2024/0979

Nailmaker Brewing Co.

5A Glassworks, Barnsley, S70 1GW

Display of internally illuminated signage to bar (Retrospective).

Proposed North West Elevation to May Day Green 1:50

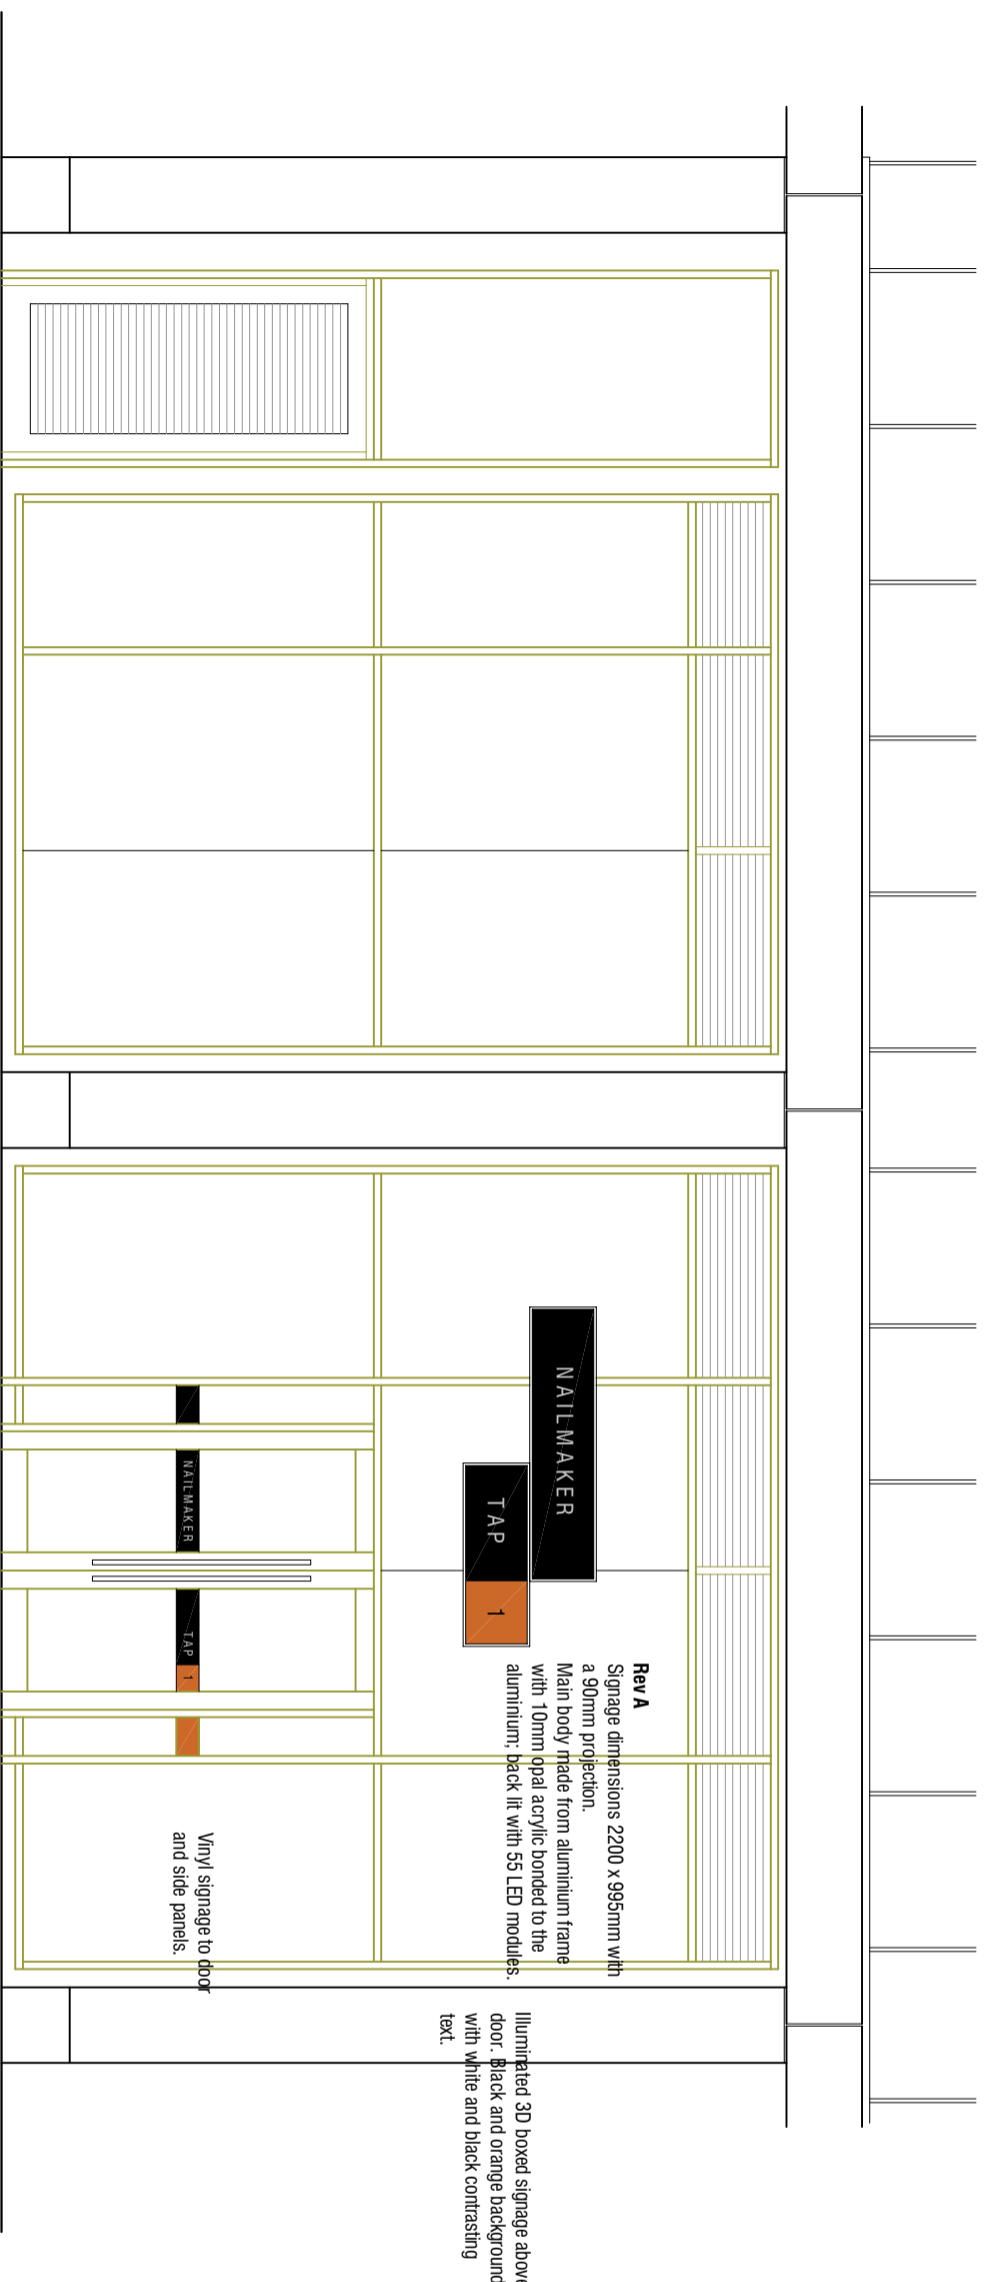
The Council's Senior Urban Design Officer was consulted, and their response states that a greater depth of projection would have been preferred to the individual letters of 'NAILMAKER TAP 1' as the installed sign adopts a minimal projection which makes the signage appear flat which is something that is trying to be avoided on the shop frontages for the Glass Works. The previous signage had a more pronounced 3D projection which was desirable. However, the retrospective signage achieves a good degree of transparency with unhindered views into the heart of the unit which reflects the overriding themes of the 'shopfront design guide for the Glass Works'. Whilst it is unfortunate that this is a retrospective application, on this occasion, it is not considered that a request to significantly increase the depth of the signage projection would be justifiable. The retrospective signage scheme sympathetically reflects the design and type of similar signage to other units within the Glass Works development and surrounding area and would adopt a consistent colour scheme throughout with an appropriate scale and level of illuminance for its setting. As such, this weighs moderately in favour of the development
